DECISION DELEGATED TO DEVELOPMENT MANAGER

Application No: H23-1157-19 **Applicant:** Hortech Systems Ltd
Proposal: Temporary siting of 3 storage containers (retrospective)
Location: Roslyn 36 High Road Whaplode
Terminal Date: 23rd March 2020

BLOCK PLAN 1:500

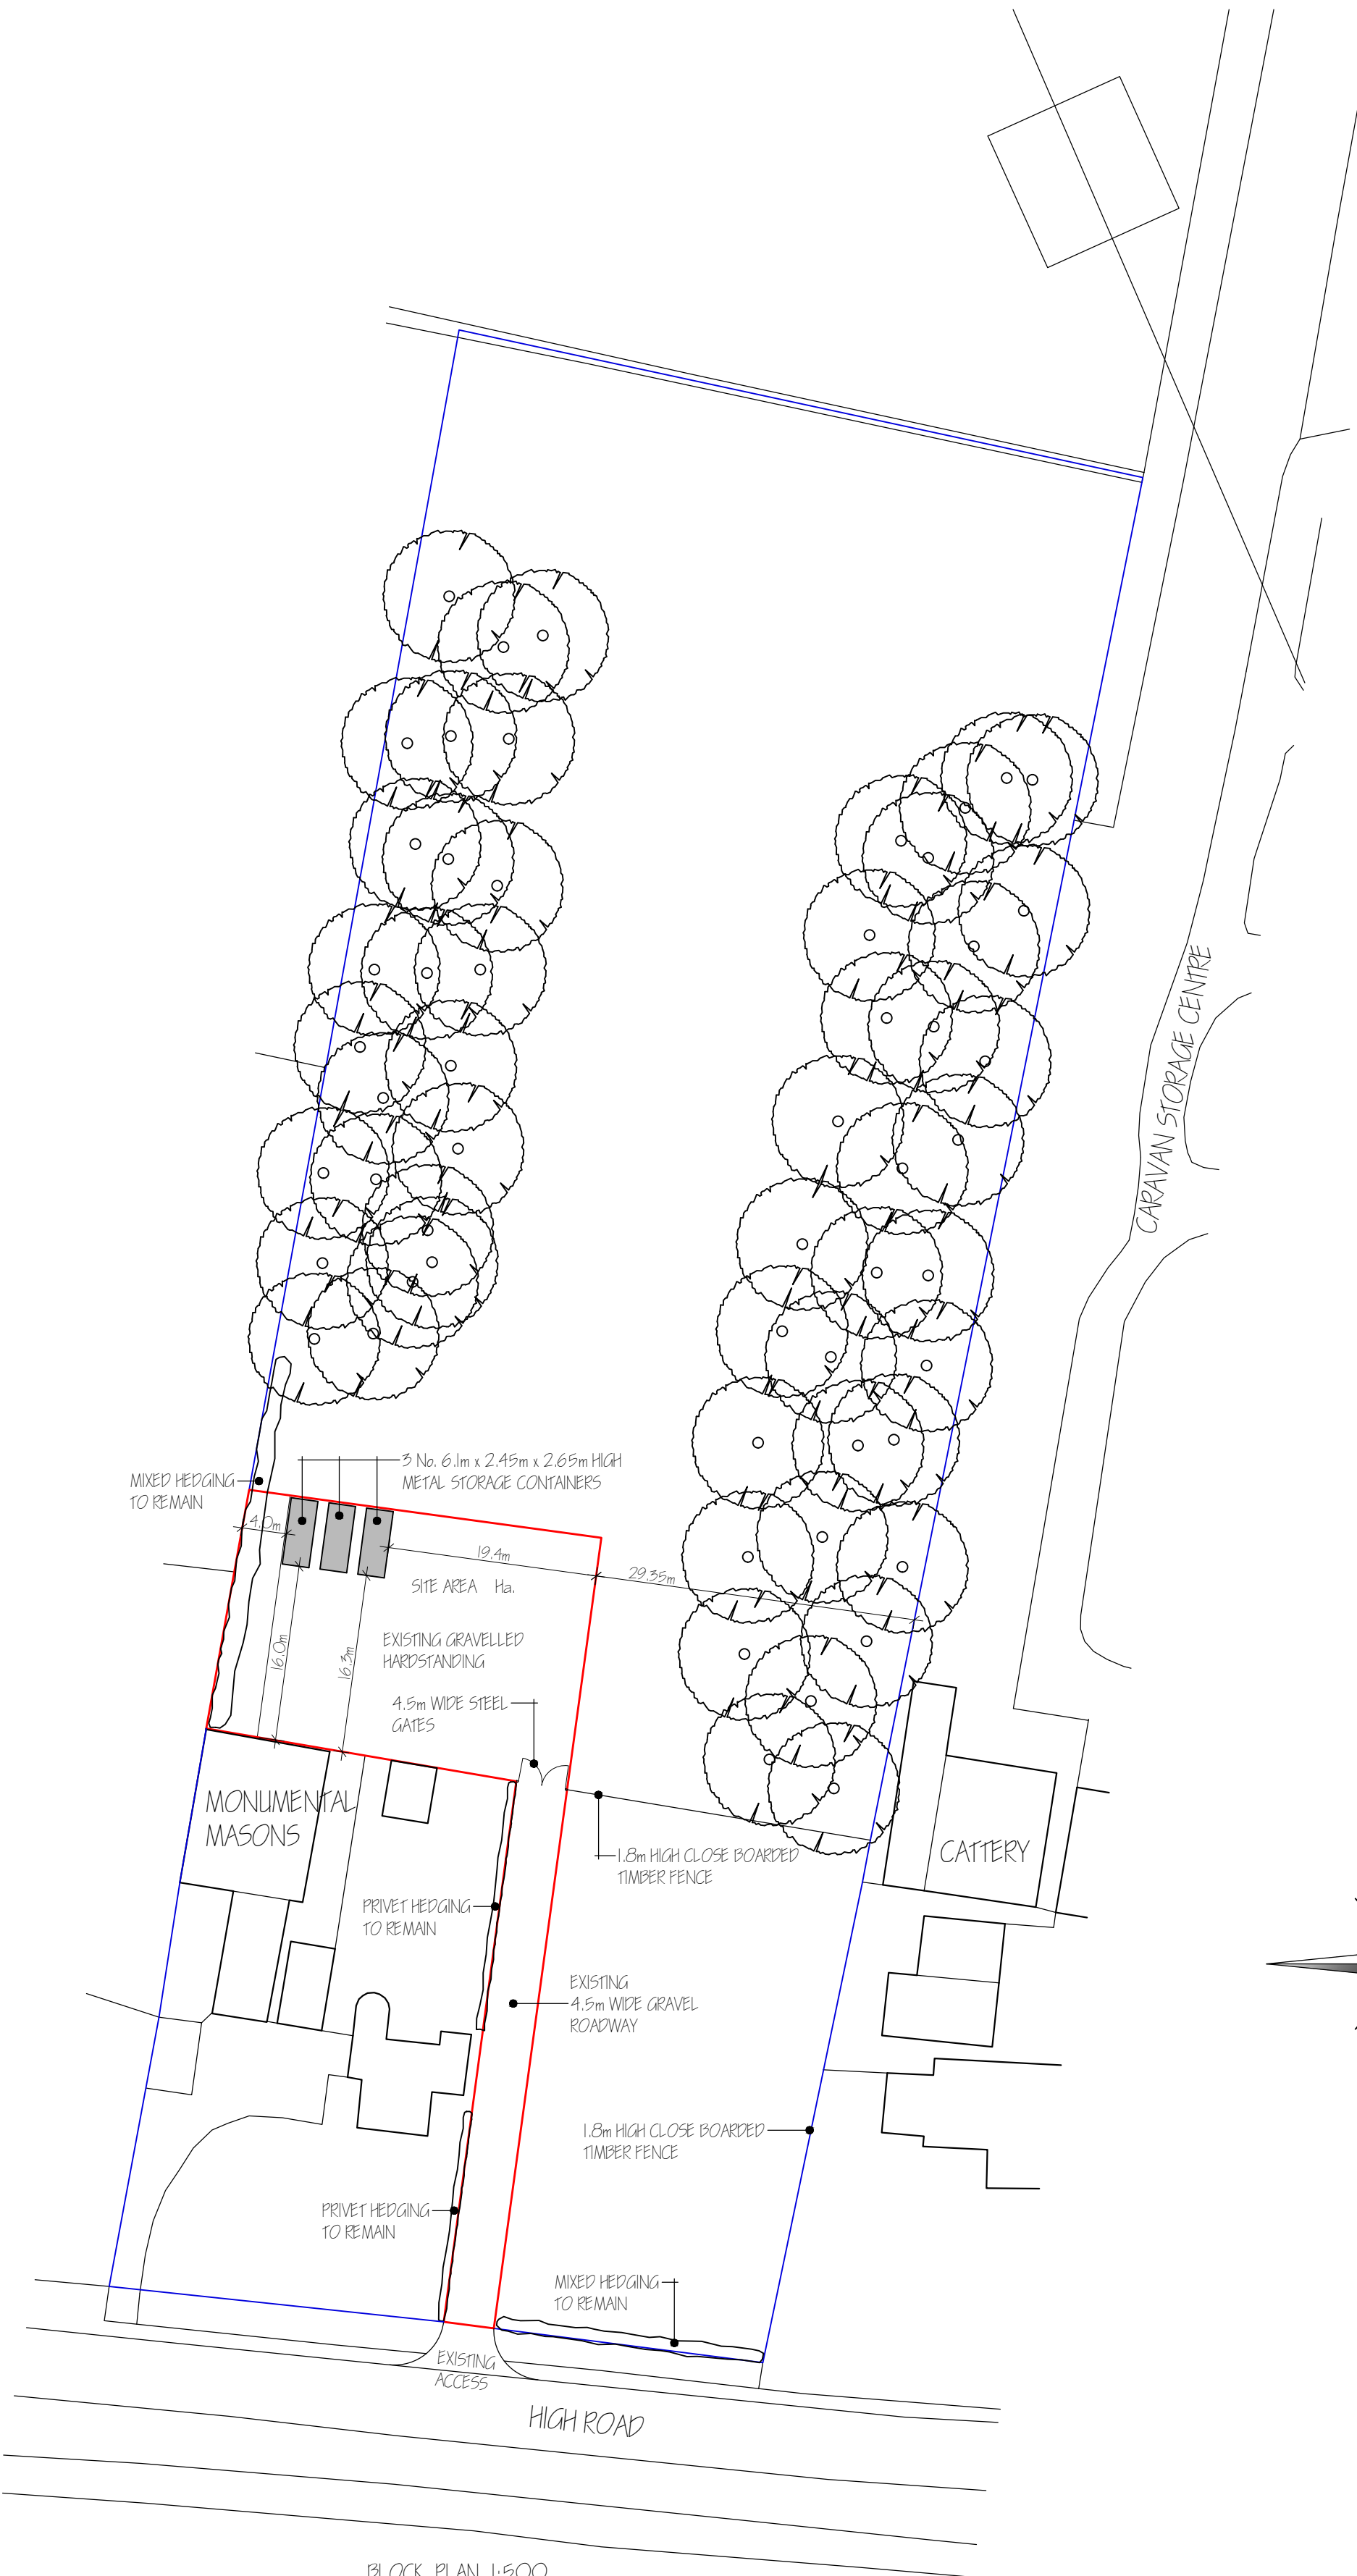
The proposed block plan shows a gravelled hardstanding area approximately amounting to 745 square metres. The gravelled roadway has been created to serve access from High Road to the site. In addition to this site access, a nearly 2 metre high fencing and gates have been erected and those works fall under permitted development rights. Therefore, no planning permission should be sought for boundary treatment and surface works.

The submitted block plan shows three metal storage containers set back in the region of 16 metres from the rear boundary of the domestic curtilage of No. 36. Two of them are already on site. The scale and height of the units are such that the development does not appear disproportionate with the boundary treatment and neighbouring properties in the vicinity. The metal containers though constitute a form of development more temporary and of lower quality standards than the sounder storage outbuilding which was refused under application ref. H23-0654-18.

The overall appearance of the development is at odds with its rural setting. This harm might have been outweighed should the proposals had complied with the criteria for new development in the countryside such as the aforementioned Policy 1 of SELLP, 2019. However, the need of the development at such location has not been demonstrated neither the commitment with achieving sustainable development and therefore the design and layout of the proposal could have been improved to mitigate their impact onto the rural setting.
